MMC Site Plan Check In meeting 3/1/2018

Key points from the **3/1/18** Site Plan Review meeting with MMC:

STEEL DELIVERY ROUTE

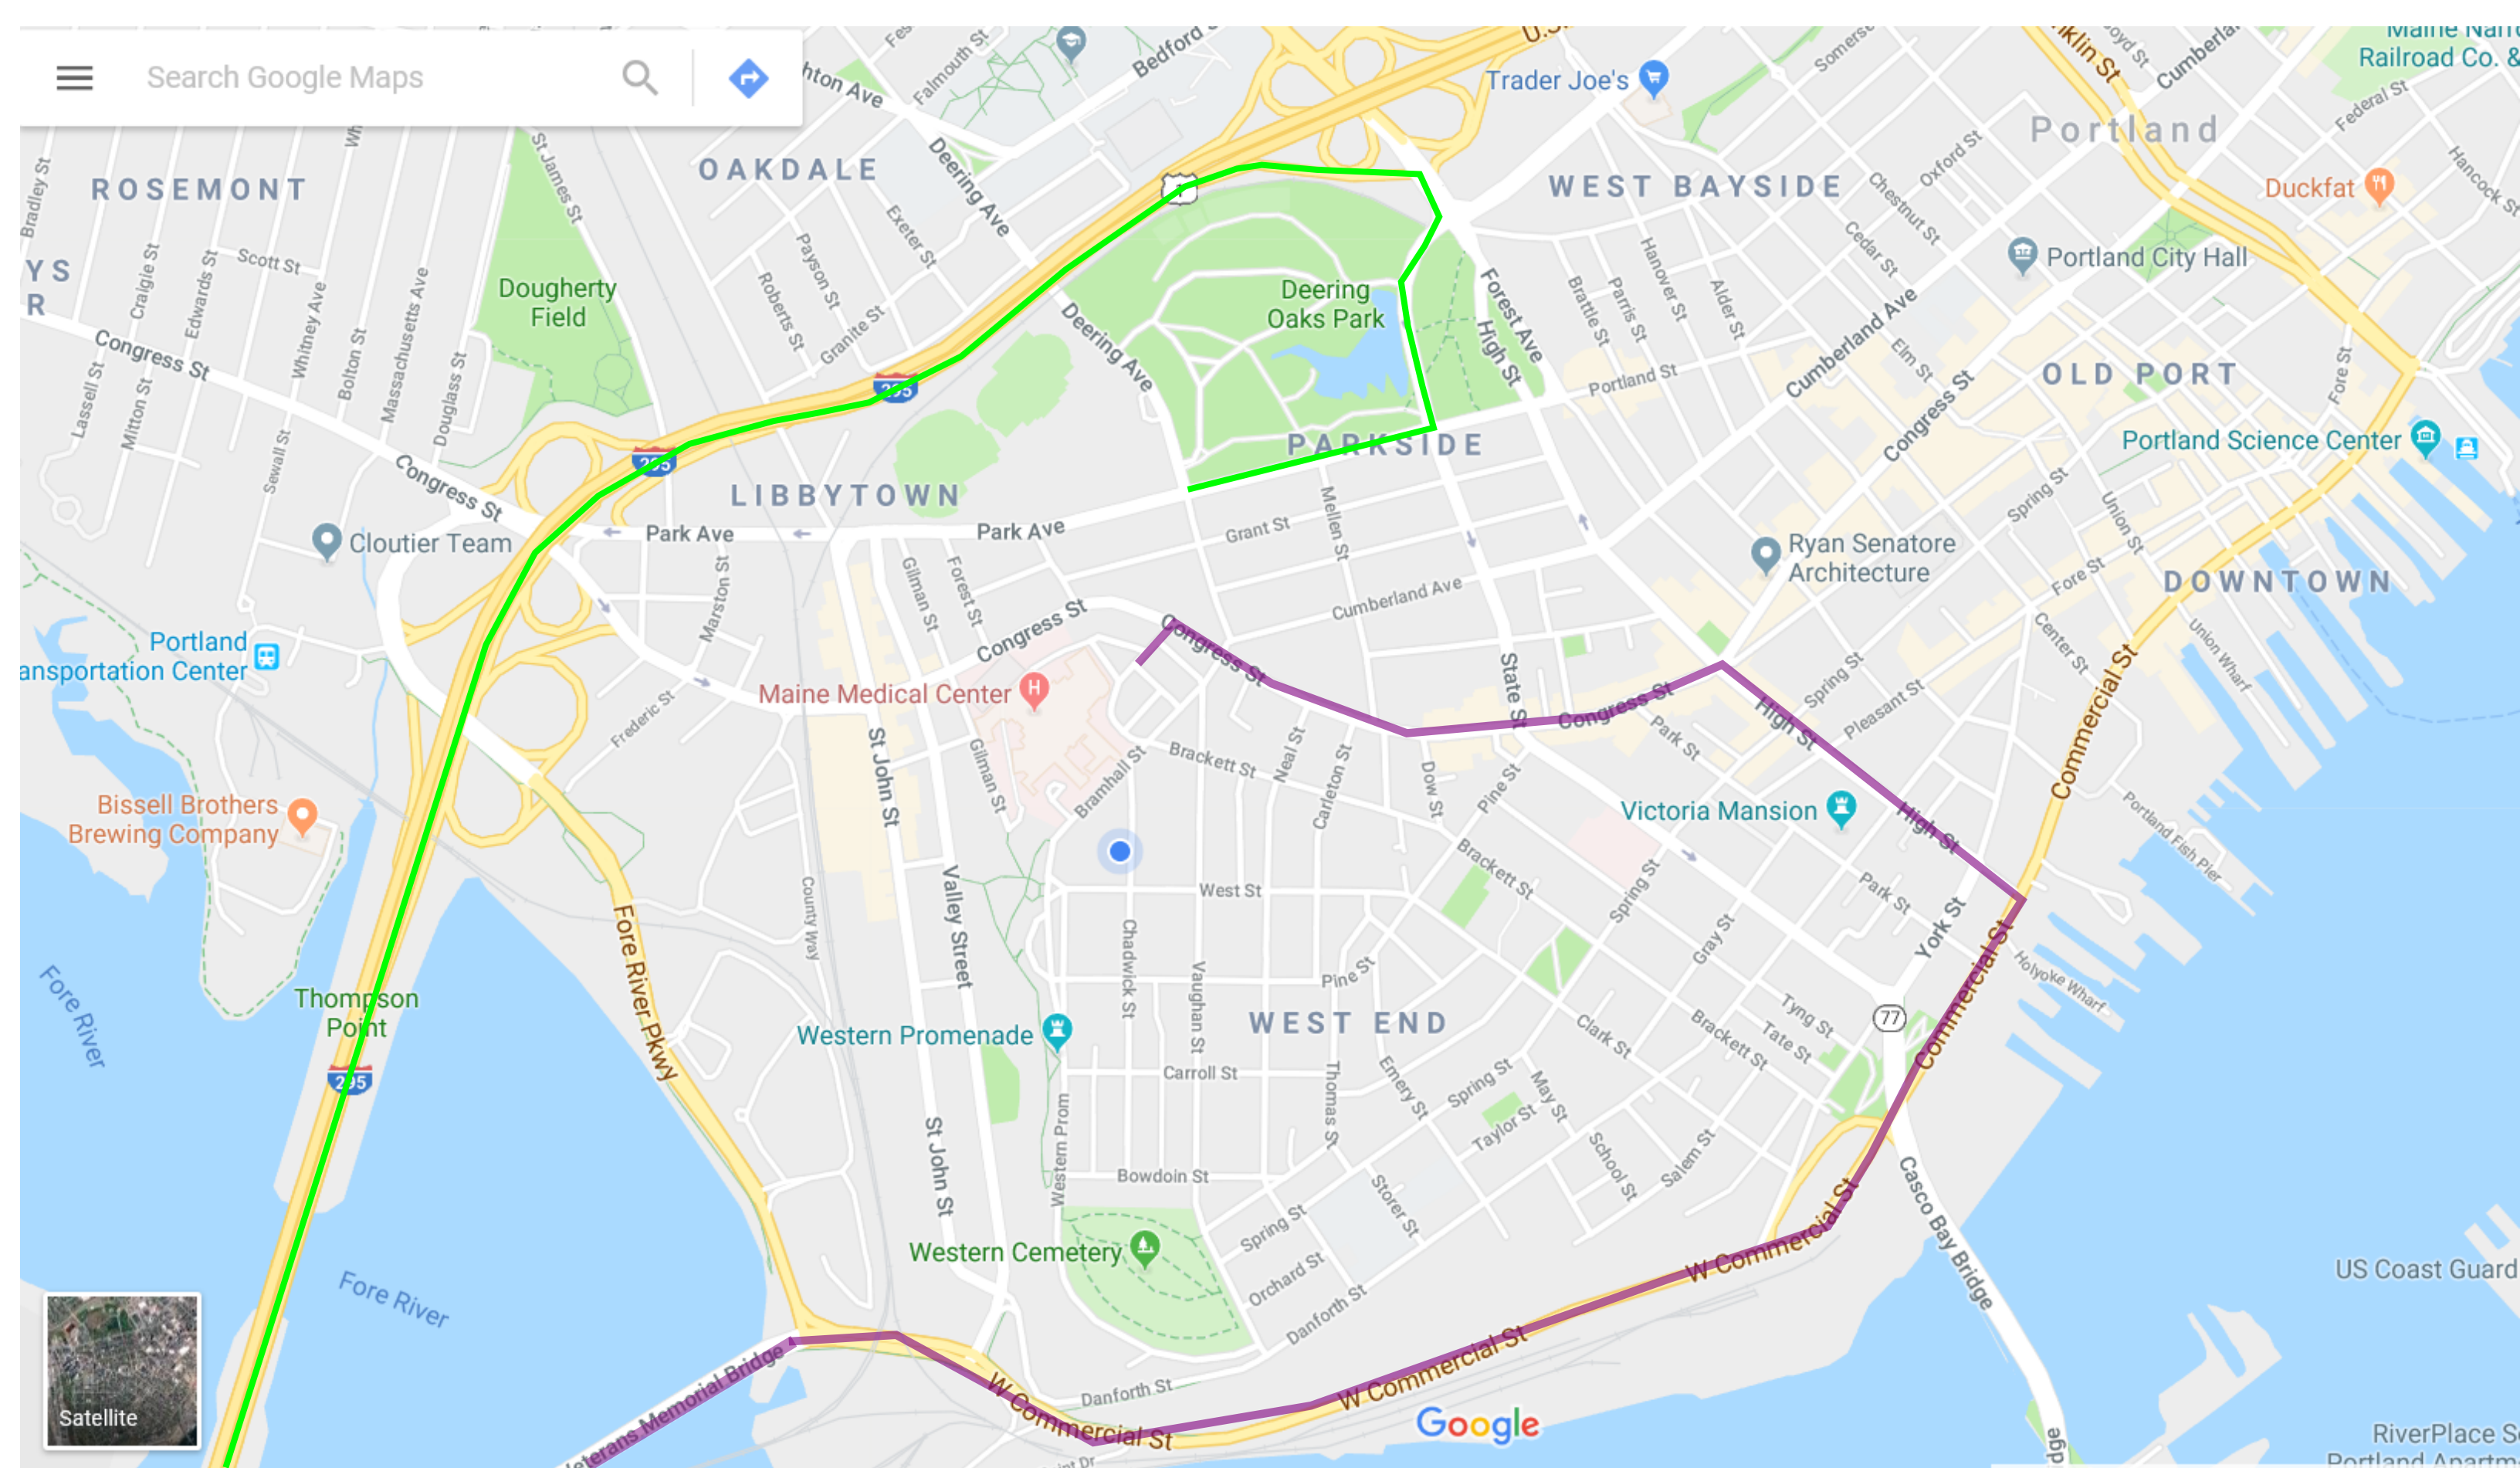
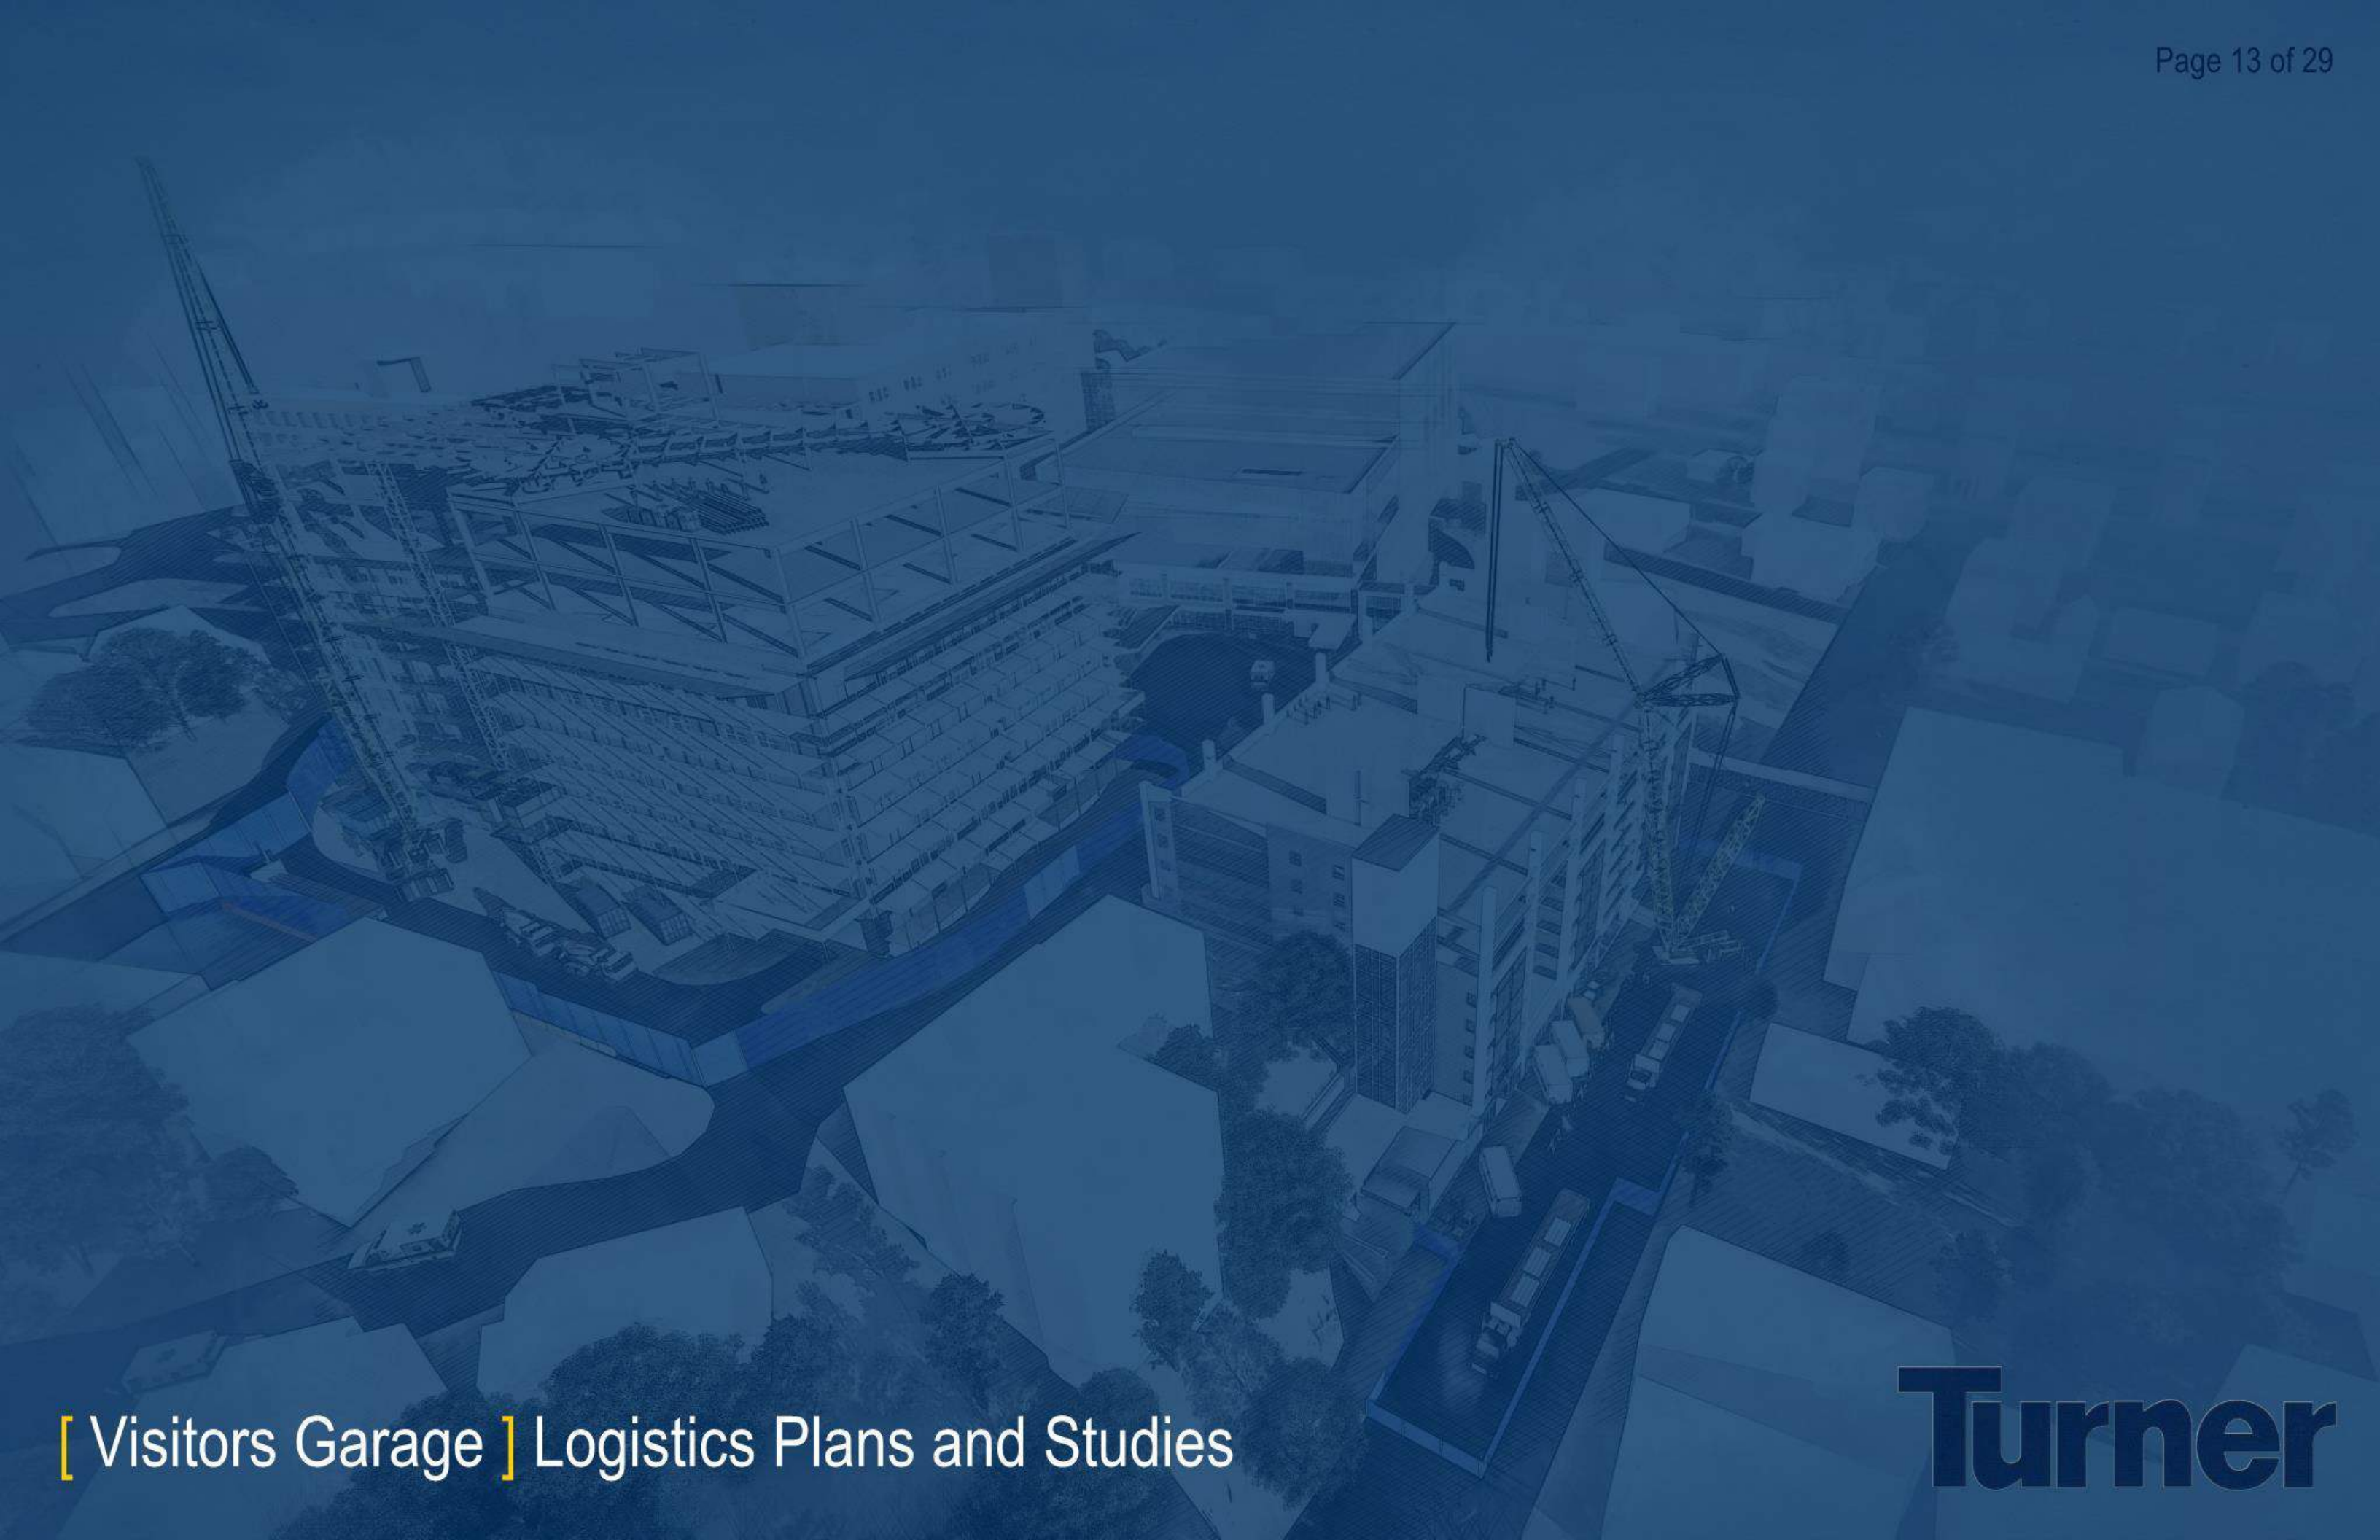
- At the 2/15 meeting reviewers questioned the proposal to route steel deliveries (from North, June 4 to June 28, starting at 5am; 3-4 /day) along Washington Ave and Congress
 - City staff advised route should avoid Washington completely due to planned construction work
 - Route must avoid downtown Portland and Congress
 - Keep delivery vehicles on I295 longer - maybe I295 to Forest /Park ? Deering; maybe Fore River Parkway
 - Turners were going to speak to the trucking company again and get back to us
- Turners had discussed further with trucking company
 - Looked at a number of alternatives
 - Those at the meeting preferred the incoming route to be High to Congress to Ellsworth
 - Those at the meeting basically OK with exit route (Bramhall to Deering to Park) but may need tweaking re turn onto Park
